**Re: Del Norte Baptist Church  
5800 Montgomery Blvd. NE  
Grading & Drainage Plan Engineer's Stamp Dated 8/1/17  
(G18D010)**

Based upon the information provided in the submittal received on 8/2/17 the above-referenced plan cannot be approved for Grading, SO-19, and Paving Permits.

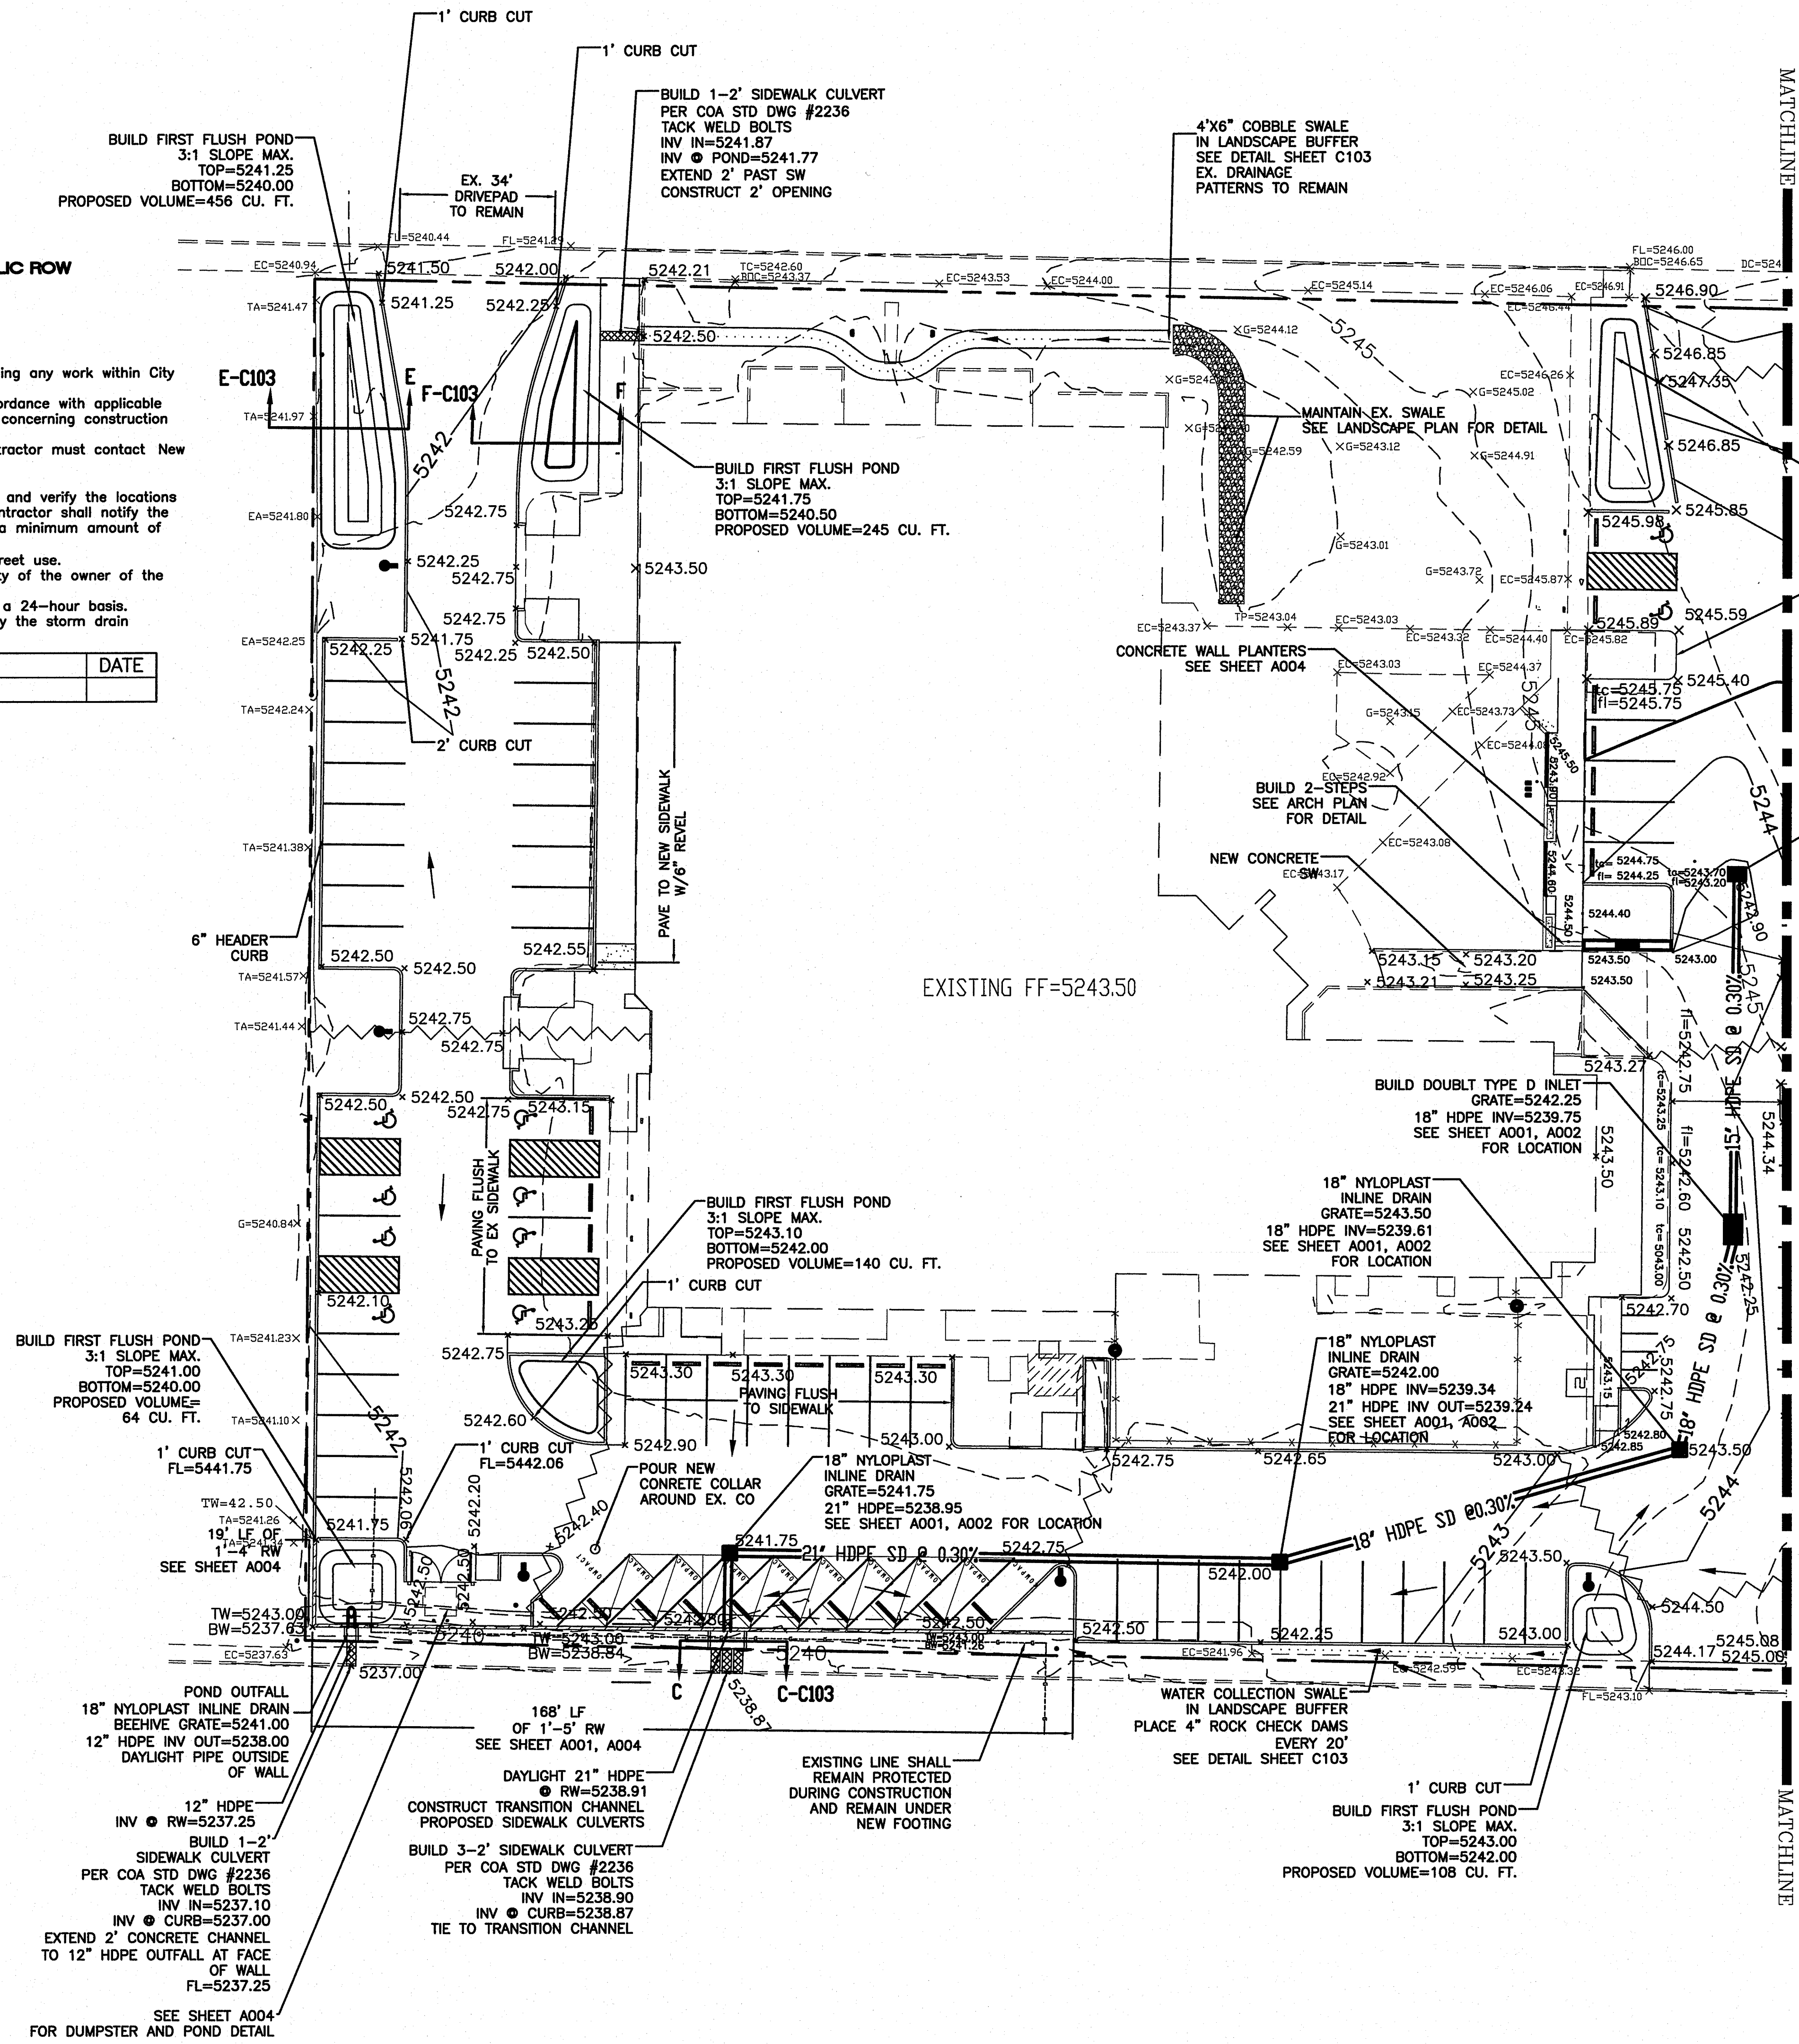
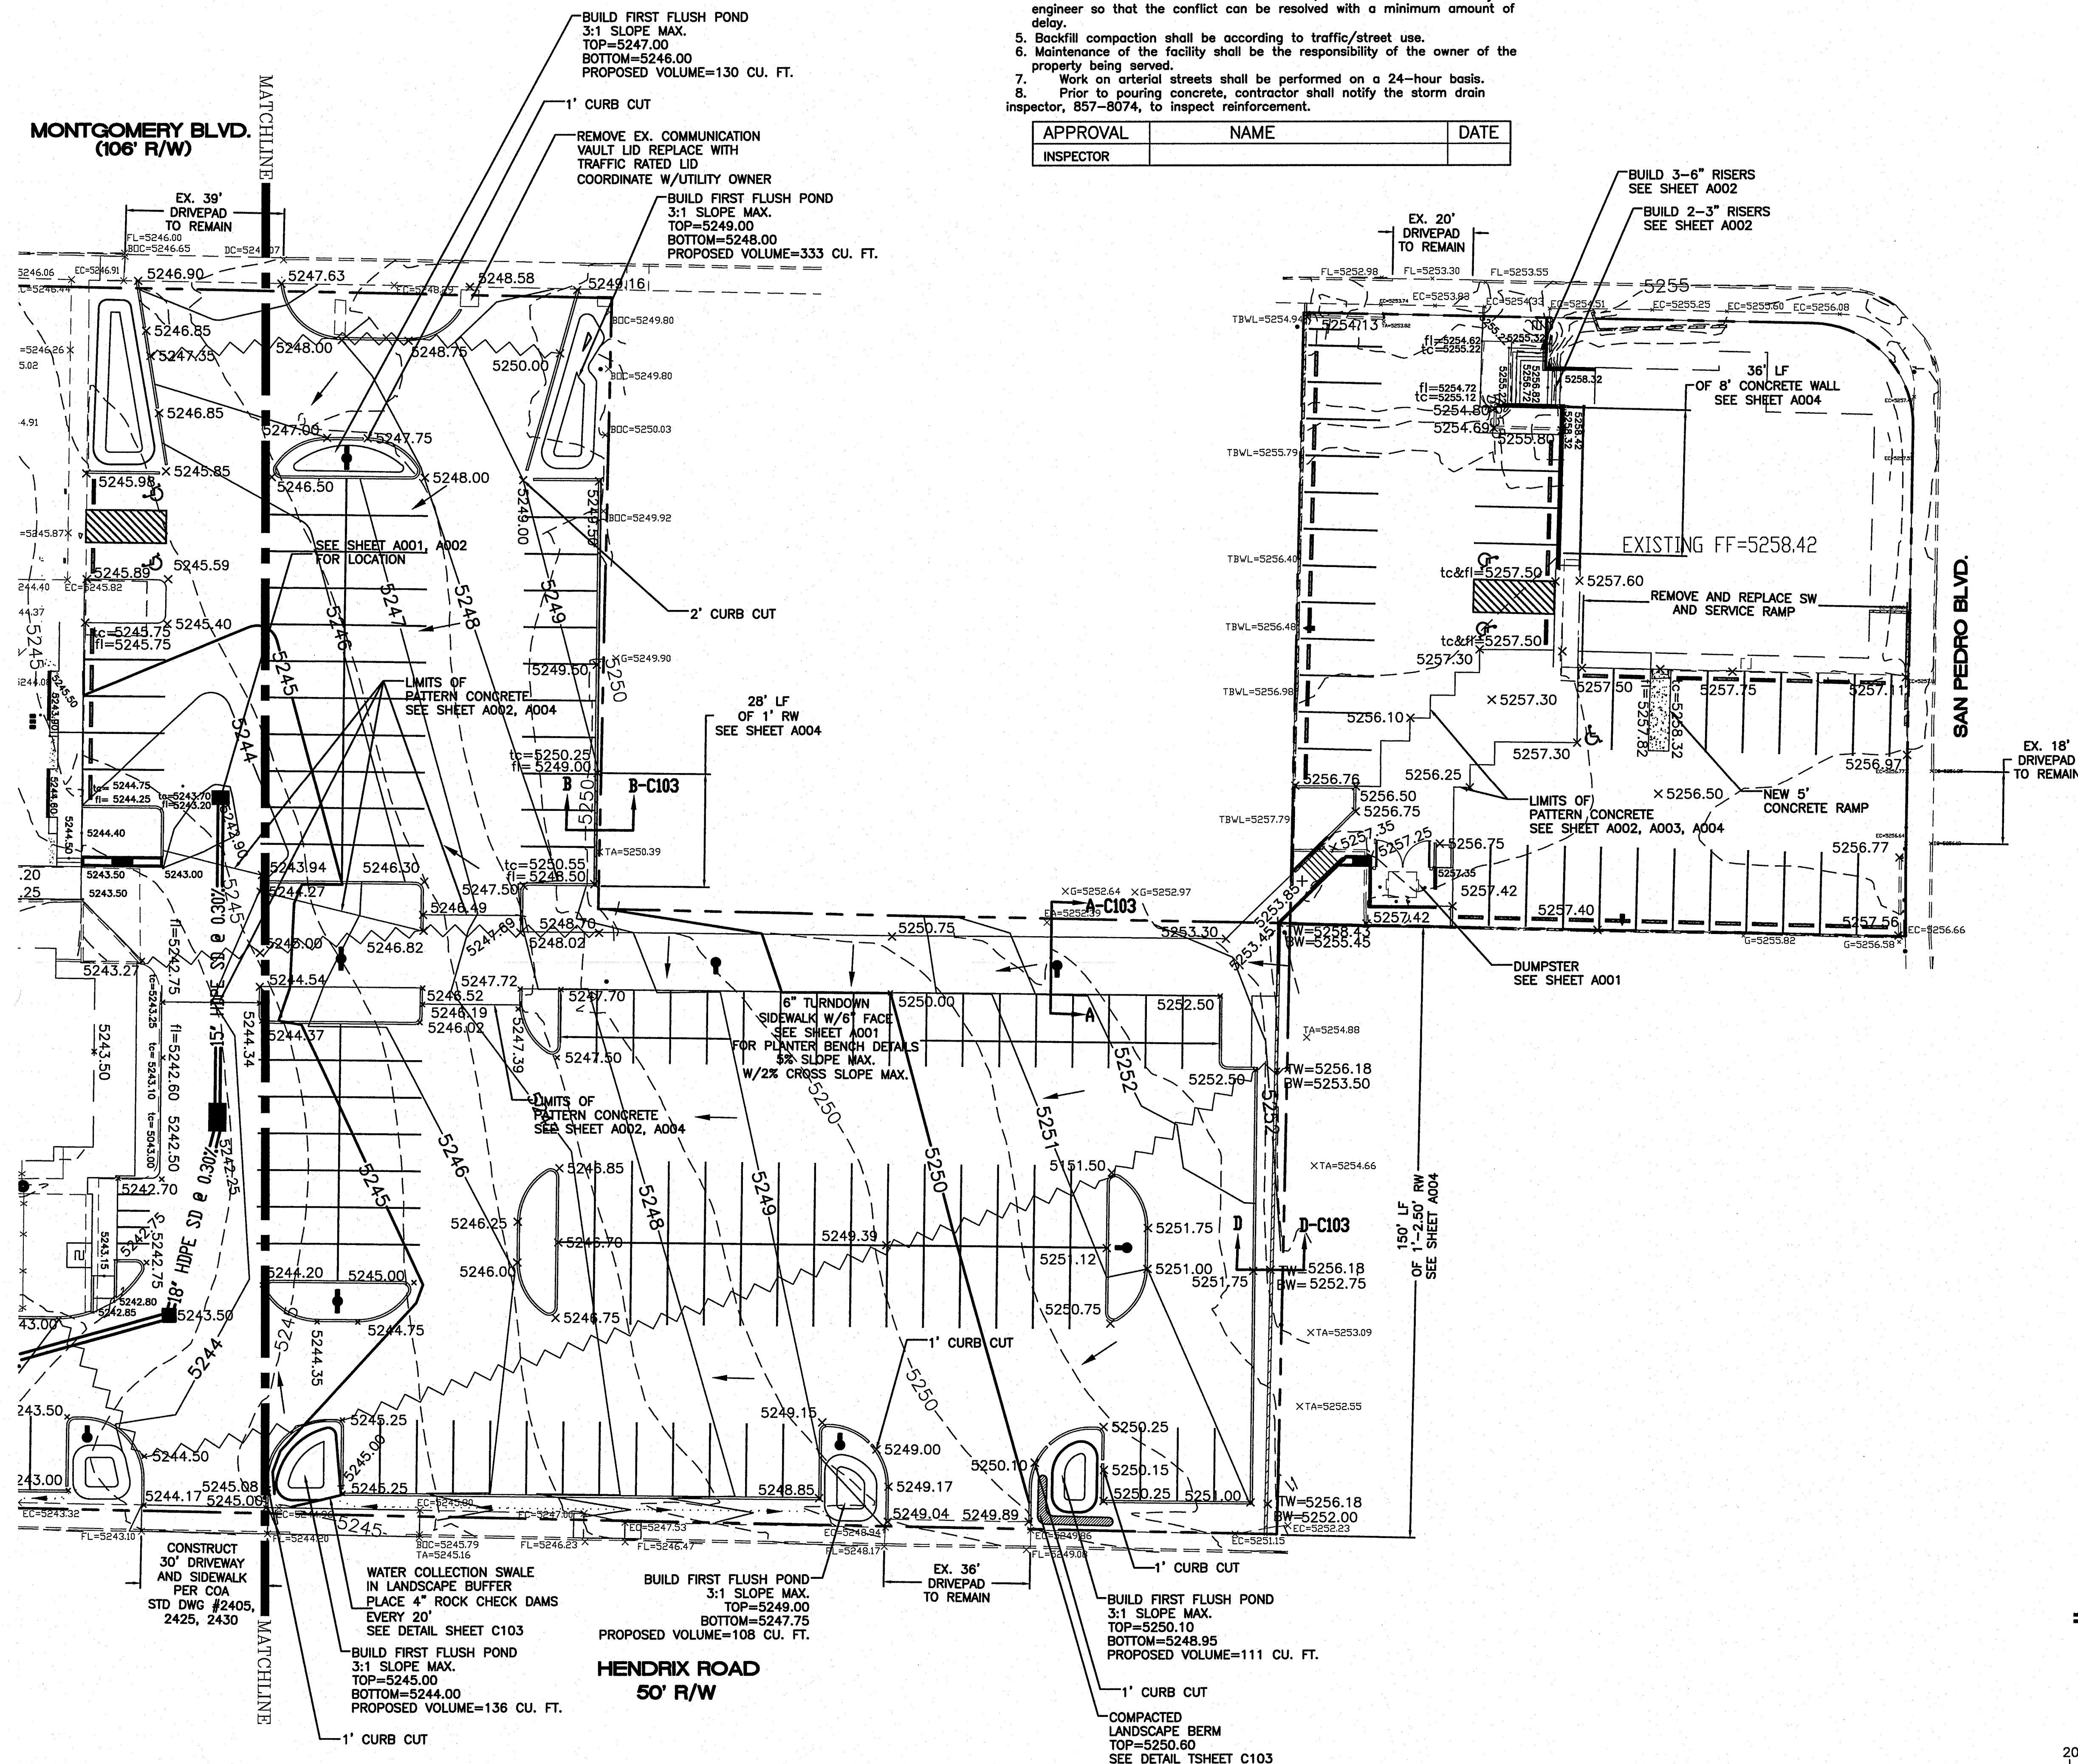
- Correct the Legal description "Lots B, C, and C2B"
- Add the SO-19 notes so that this plan can be used to obtain an SO-19 Permit for the sidewalk culverts, driveways in the public right of ways.

- Clearly indicate limits of removal and disposal on separate sheet.
- Clearly indicate new paving and sidewalks with hatch patterns and curb and gutter types to be constructed this project. Resolve discrepancy between legend and plan view.

- Topo survey needs work. Show existing drive pads, retaining walls, and slope paving more clearly on grading plan.
- Show existing elevation of adjacent properties at least 10' beyond the limits of this site, both contours and elevations.

- Add existing spot elevations all around perimeter next to each proposed elevations. Spots should be spaced about every 50'.
- Add Driveway and HC ramp detail per City Standard Specifications. Provide 0.87' water block height along Montgomery Blvd.

- Sidewalk Easement may be necessary if sidewalk jogs into private property at driveway locations.
- Proposed driveways need to be shown in greater detail with ramps, and construction notes.

- Add more typical sections around perimeter of site. More retaining walls may be needed particularly along the west side of lots C and B. Show existing walls/slopes in sections.

- Typical section DD needs more dimensions, show footer, existing ground distance to property line, and max height of retaining. Offset the wall far enough from property line so that the neighbor's property will not be disturbed during construction.
- Add existing ground and dimensions to Section BB
- Provide more sections and details for grading in landscape areas northeast of the building.
- Provide HGL calculations for onsite storm drain and add profile of pipe to the plans showing HGL and label HGL elevations, Q, and V.
- Provide actual flow depth & elevation at inlets. Add emergency overflow depth & elevation calculations for sump inlets and verify freeboard to building floor elevations.
- Provide section, profile, and details of ponds F and G. Make sure they do not drain into the private property west of this site. Provide outfall details.
